Subject: Yapton Parish Council response to Planning Application Y/92/17/OUT - Land east of Drove Lane, Yapton BN18 0EB

Y/92/17/OUT - Land east of Drove Lane Yapton BN18 0EB

Outline application with all matters reserved save access, for up to 300 dwellings, link road, surface drainage, open space and landscaping

FIGURE 45. Plan showing density ranges across the allocation site

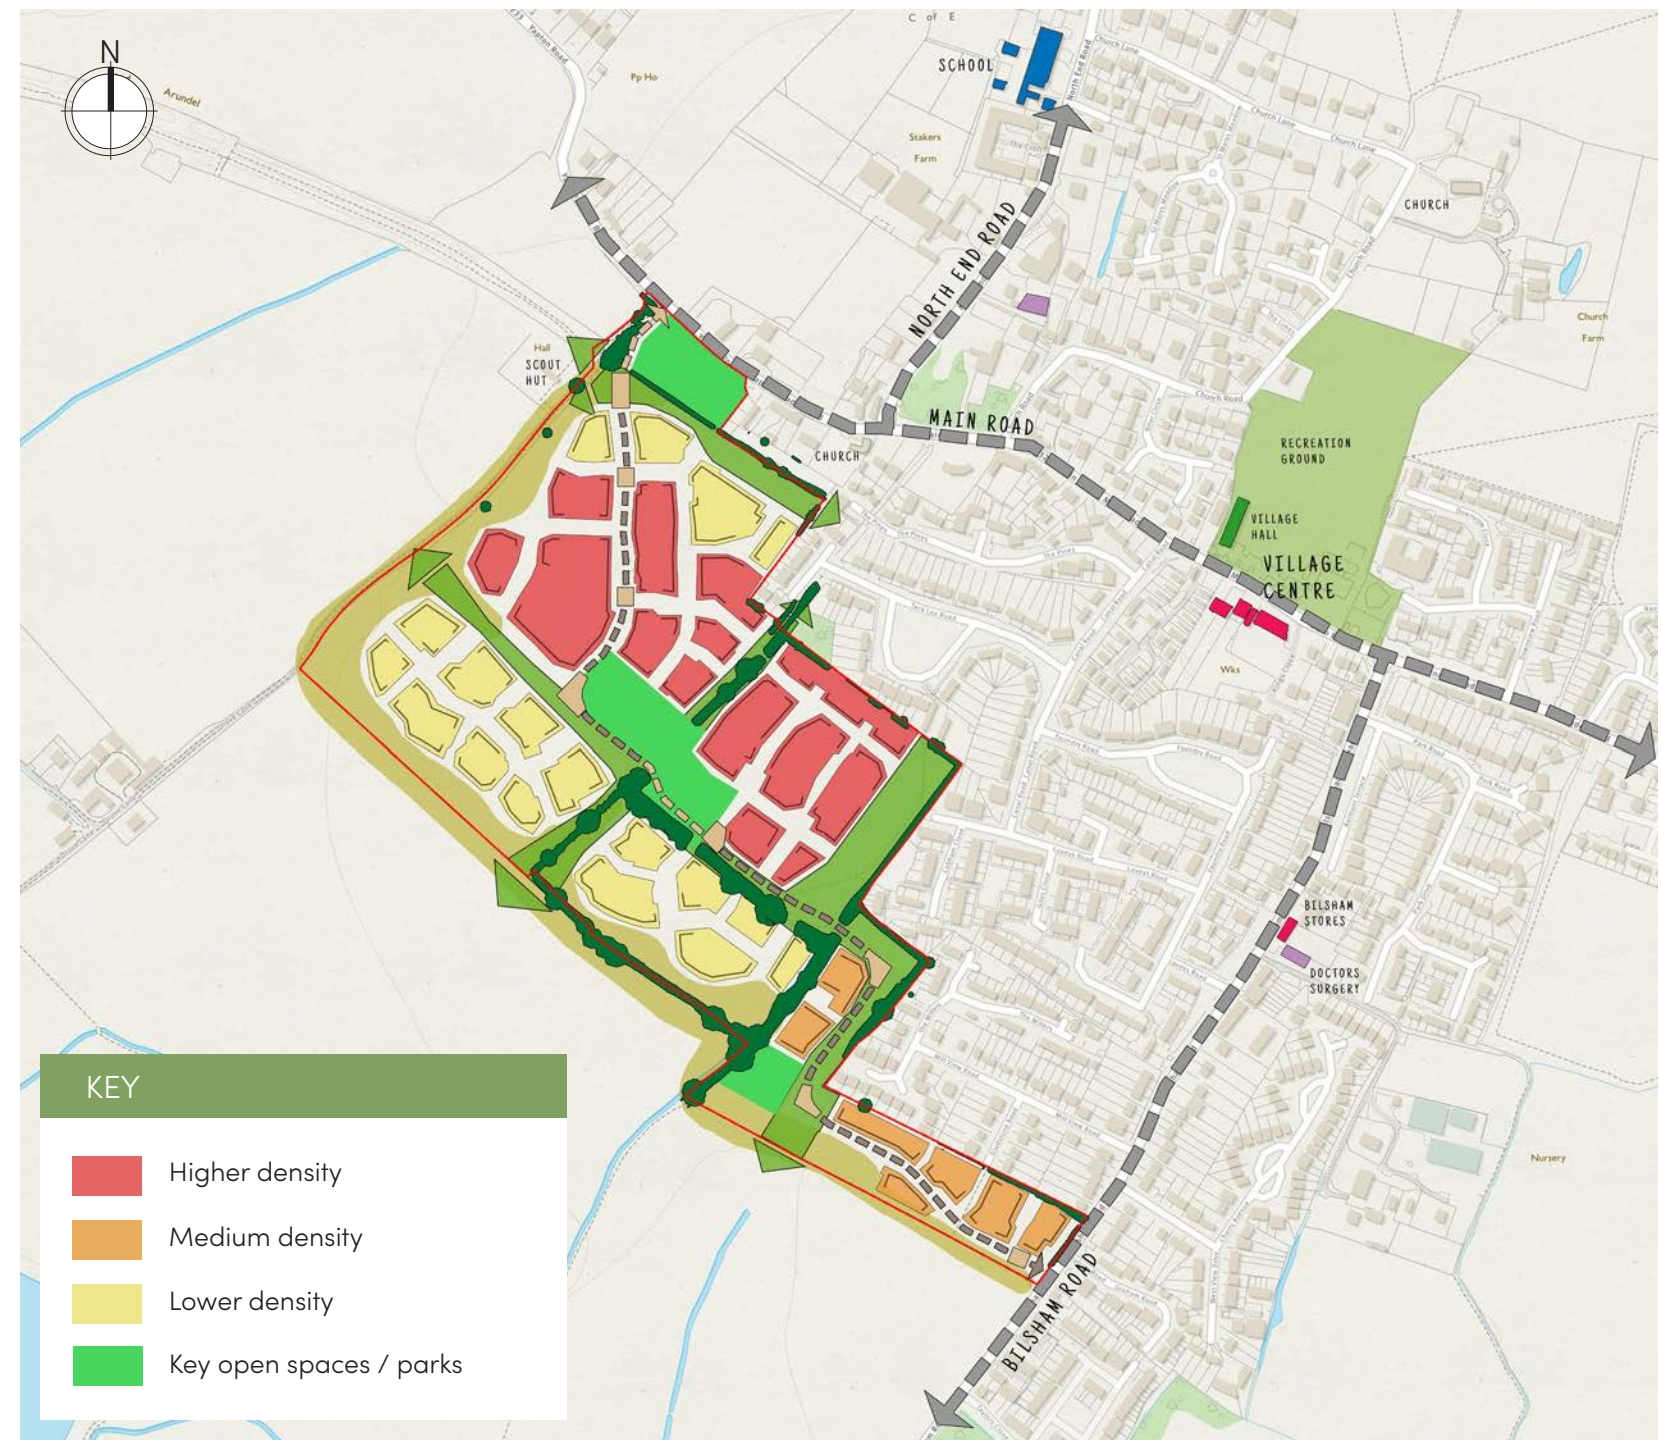
- a. YPC welcome the suggested massing and density of the built-up areas especially the inclusion of bungalows. YPC are pleased that the rural nature of the village will be reflected throughout the scheme in terms of design, green space and type of dwelling.
- b. However, YPC are concerned that the use of 'Landmark' buildings may inadvertently create an urban environment opposed to extending a rural village. YPC seek that 'Landmark' buildings are created through good use of materials and landscaping rather than as suggested through height as this would be incongruous with the existing built environment in Yapton.

APPENDIX 6
Improvement Works Drawing

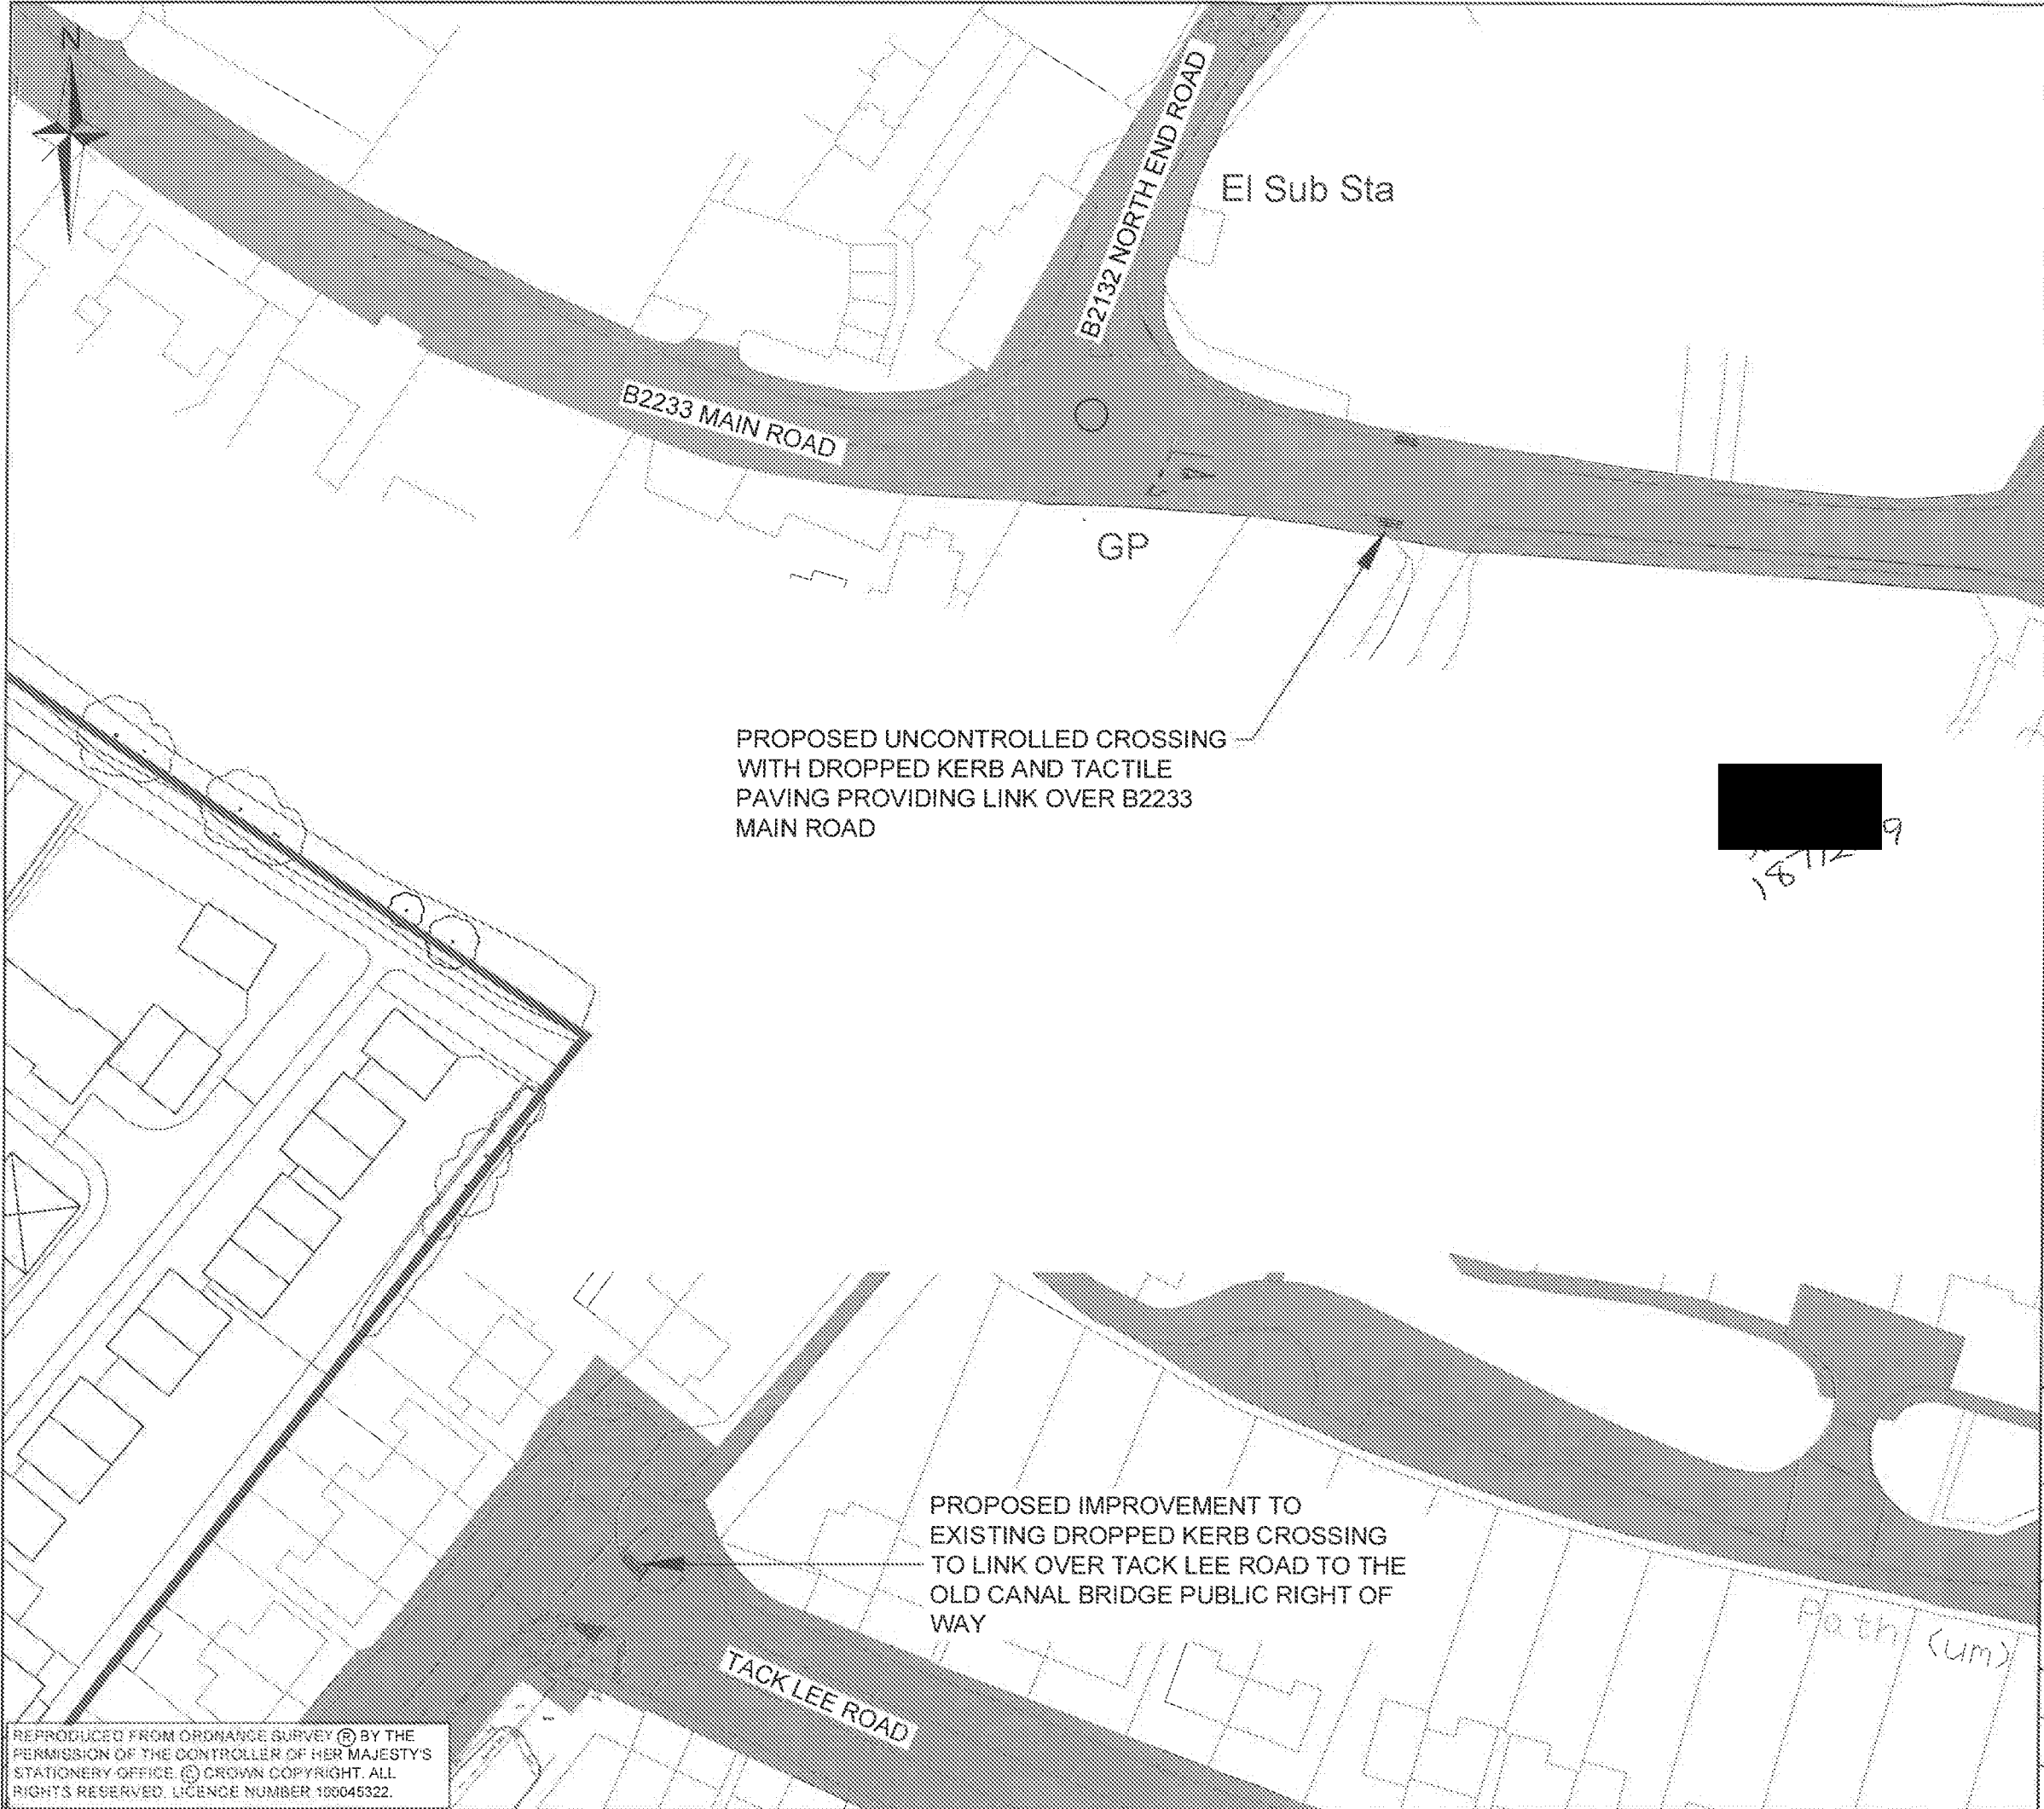
- d. The masterplan embraces the need to link the new community with old especially via sustainable links such as footpaths and cycleways. YPC welcome this but insist that there is a need to ensure a pelican crossing is put in place on Yapton Road near the junction with North End Road to ensure safe crossing to the north of the village which accommodates both the Primary School and one of the two Doctor's surgeries.

- b. YPC request that to ensure safe and free movement from the site to existing facilities pelican crossings are put in place along Yapton Road near to North End Road. This would ensure safe access to the Primary School, Church and Doctor's surgery.
